Our ref: DOC21/457135-7

Your ref: SSD-6612

Martins Creek Quarry Project (SSD-6612) – Review of EIS

Martins Creek Quarry Project (SSD-6612)

FIGURE 6.39  
Final Landform  
Cross Sections

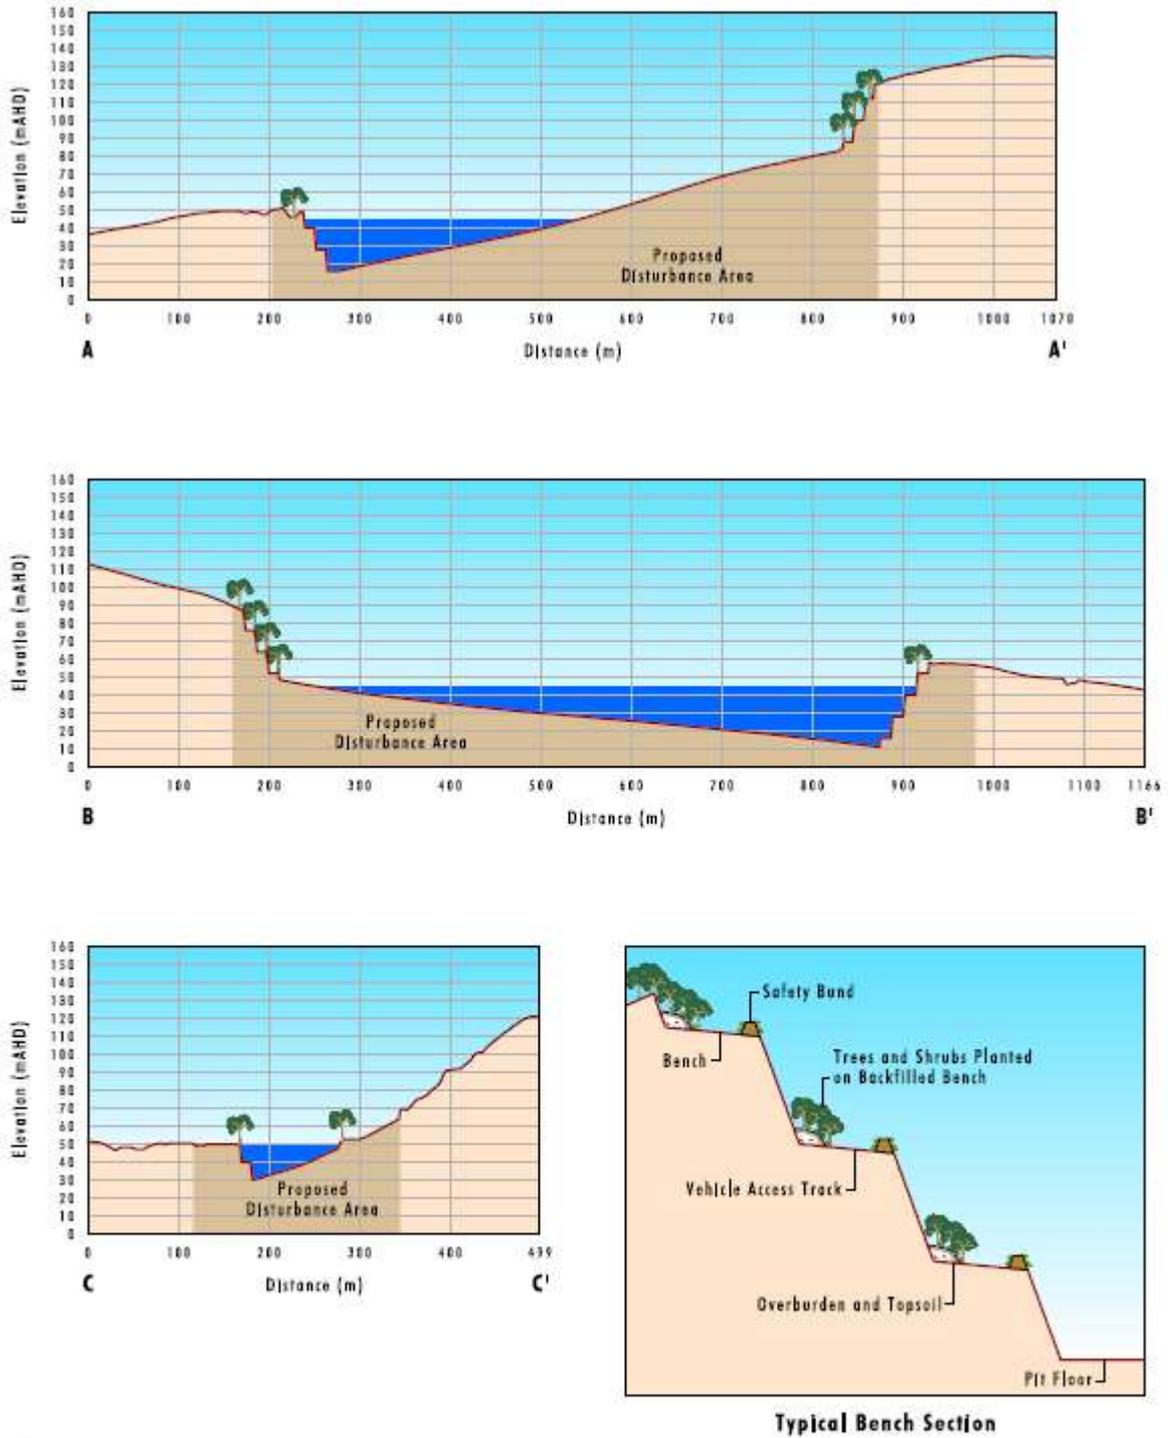
Figure 5.1 of the rehabilitation strategy indicates that two permanent voids will remain in the rehabilitated landscape. The west pit void is very large in size and the Surface Water Impacts Assessment indicates it will take approximately 22 years to fill. The smaller east pit is estimated in the report to take 8 years to fill. This means that water from within the catchment will not report to the downstream waterway for the full duration of the time taken to fill the remaining voids. During operation this water would be returned to downstream areas via pumping. These impacts will be exacerbated by ongoing evaporation loss from the voids.

Loss of water to the downstream ephemeral waterway is likely to have an impact on the riparian vegetation which has not been considered.

In addition, the manner of discharge to the downstream waterways in a flood event will also change post-rehabilitation. Once the storage fills discharge will be via weir flow to the receiving environment with unknown effect on downstream flooding and erosion. No assessment has been made on the changed hydraulic behaviour post rehabilitation.

The hydraulic impacts of inclusion of large mine voids in the final landform on downstream flooding and streambank erosion should be assessed.
